Phone: 0300 123 6780
Email: lhscustomerservice@lancashire.gov.uk
Your ref:
Our ref: LHS/CS/APP/T2350/W/16/3146390
Date: 15th April 2016

Proposal:	Replacement access road onto Stoneygate Lane
Location:	The Paddocks Stoneygate Lane Ribchester PR3 2ZS
App Ref:	APP/T2350/W/16/3146390

drawing
PROPOSED NEW
ENTRANCE DRIVE

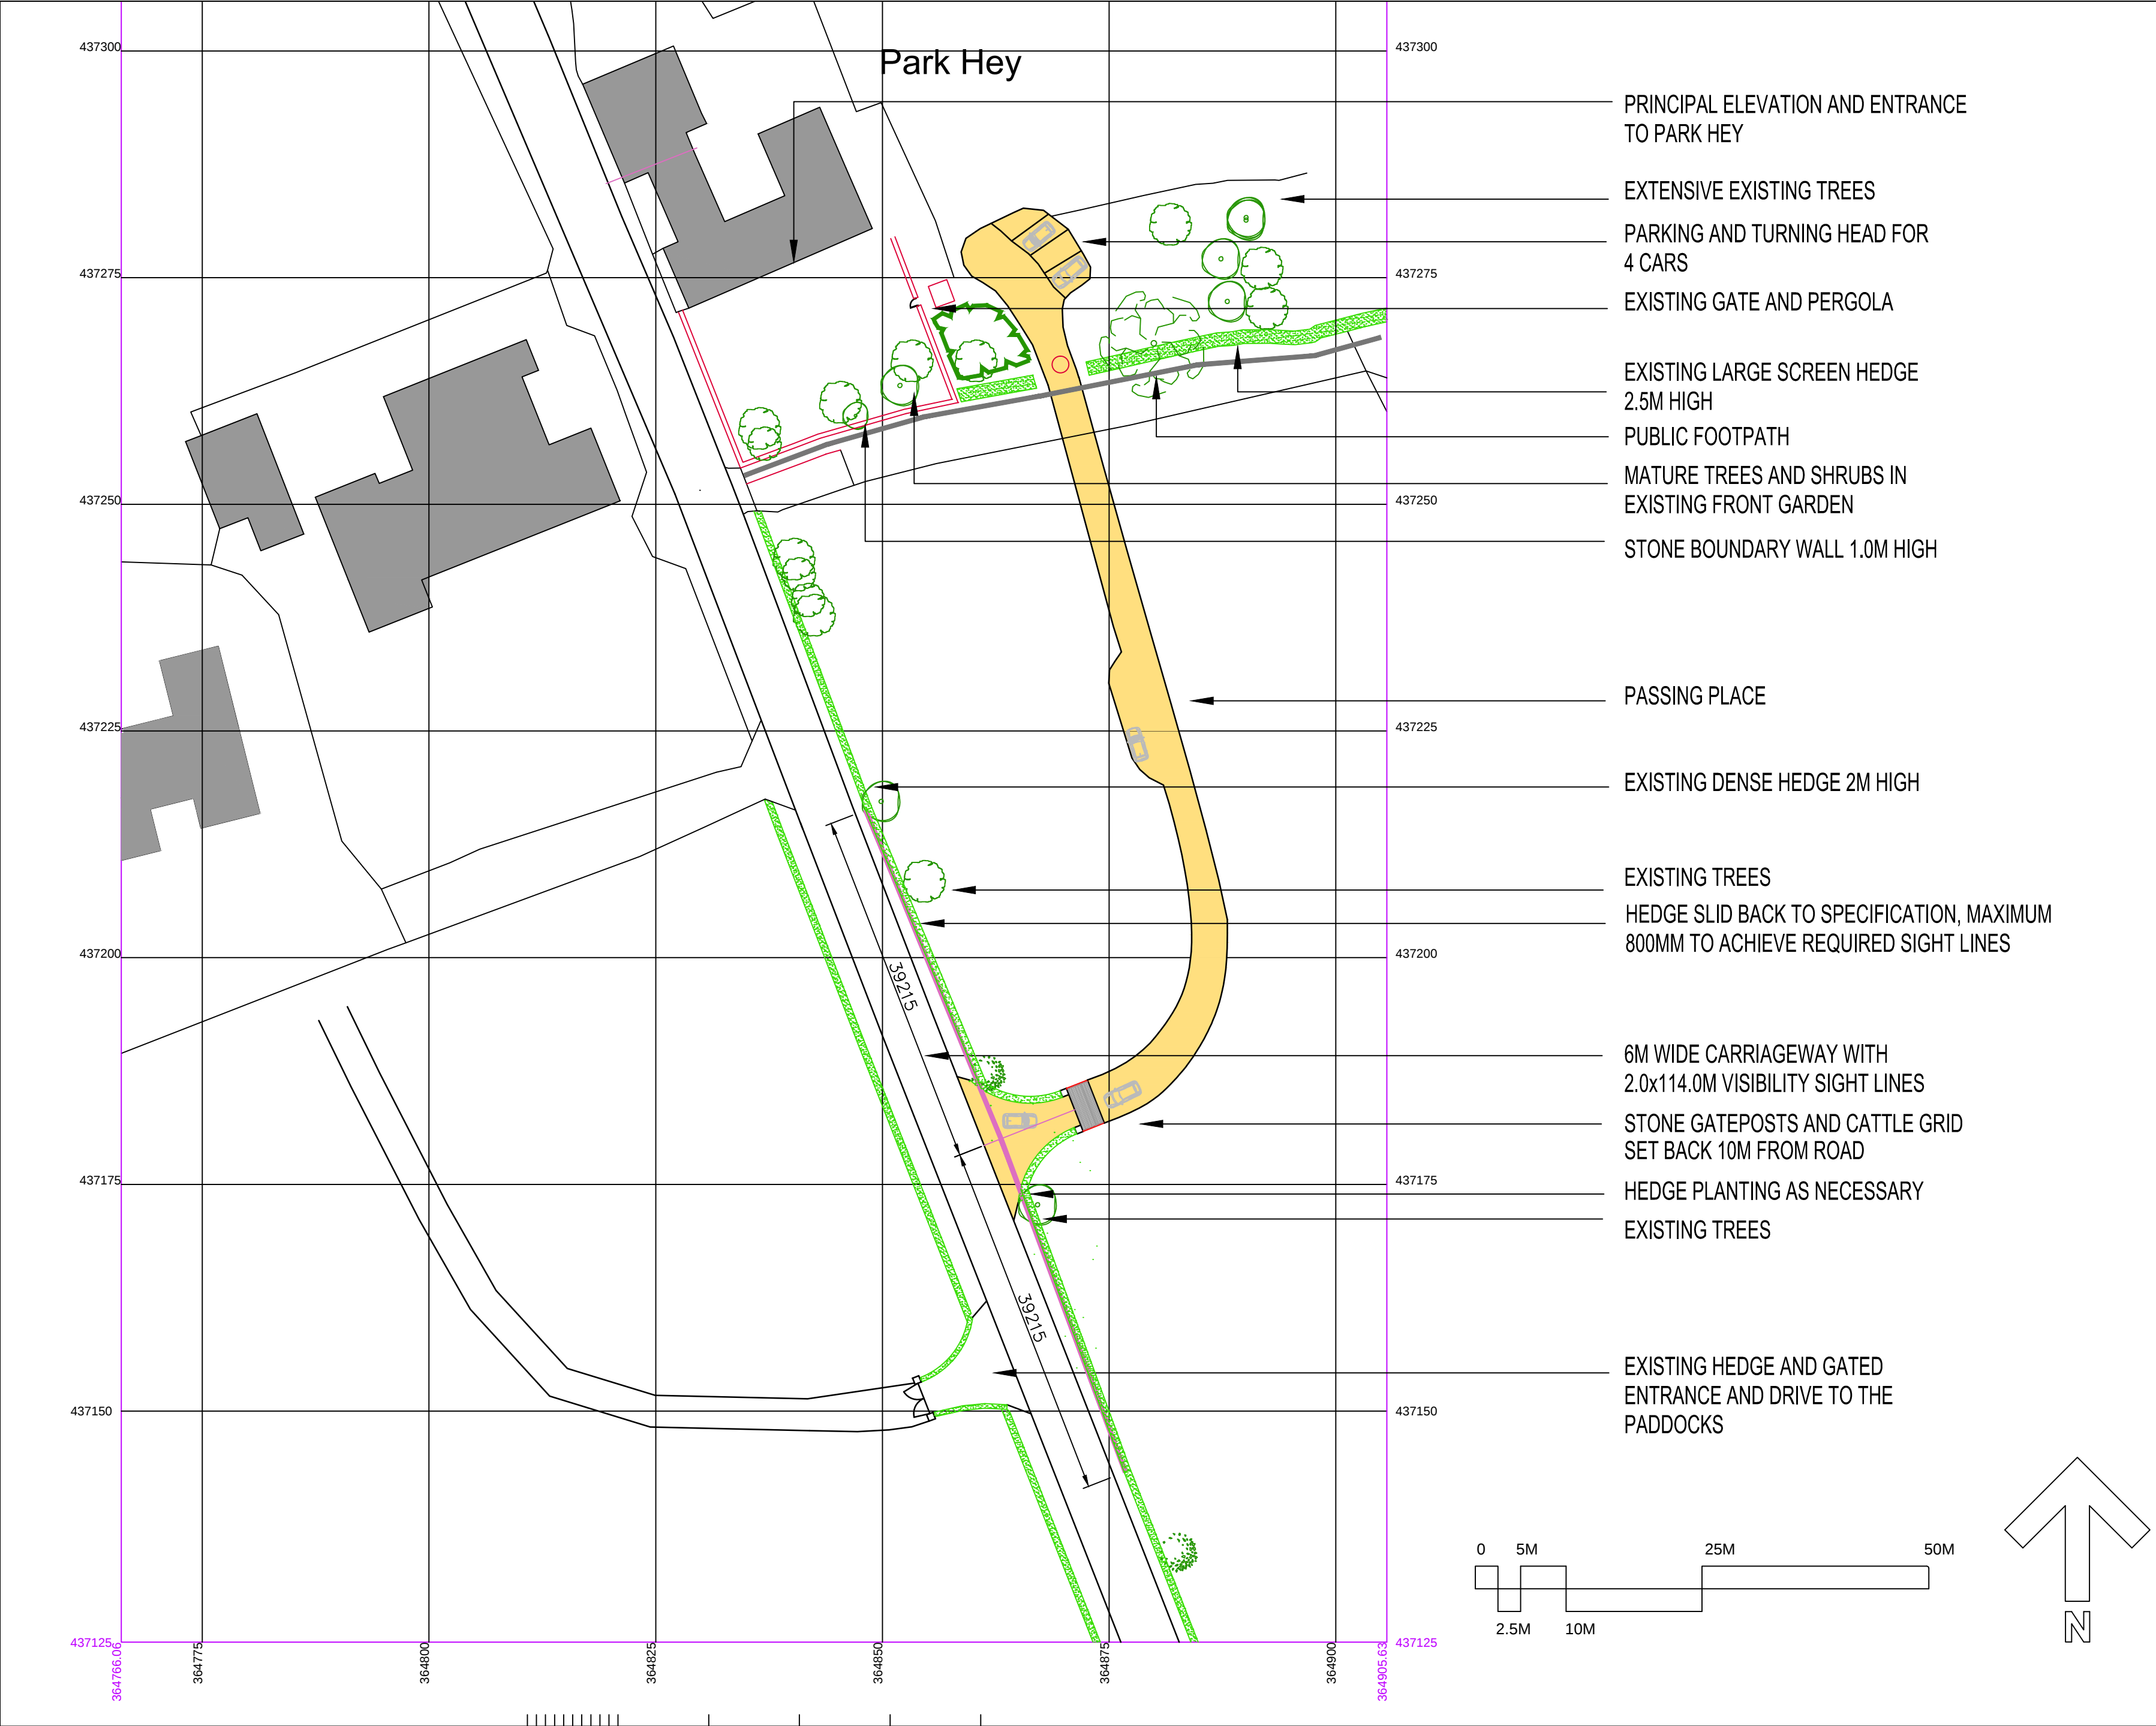
The sight lines of 2.0 x 114m to be provided in both directions from the centre of the new site access onto Stoneygate Lane. The site line requirement is, based on the basic formula for calculating Stopping Sight Distances (SSD) in table 10.1 from Manual for Streets 2, the addition of 2.4m and an the estimated speed of 50 mph.

The applicant should provide accurate details of the required sight line requirement, before determining the application, ensuring the entire sight line requirement is fully over land fully within the applicants control and/or over the adopted highway.

From observations on site and the information provided on the applicant's site location plan the sight line requirement is fully achievable over the applicants land and the existing adopted highway. The main issue is the continued maintenance of the hedge.

1. No part of the development shall be commenced until the visibility splays measuring 2.0 metres by 114metres in both directions to be provided, measured along the centre line of the proposed new road from the continuation of the nearer edge of the existing carriageway of Stoneygate Lane, to the satisfaction of the Local Planning Authority. The land within these splays shall be maintained thereafter, free from obstructions such as walls, fences, trees, hedges, shrubs, ground growth or other structures within the splays in excess of 1.0 metre in height above the height at the centre line of the adjacent carriageway.
Reason: To ensure adequate visibility at the street junction or site access in the interest of highway safety in accordance with Quality of Development Policy and Transport Policy in the Local Plan.
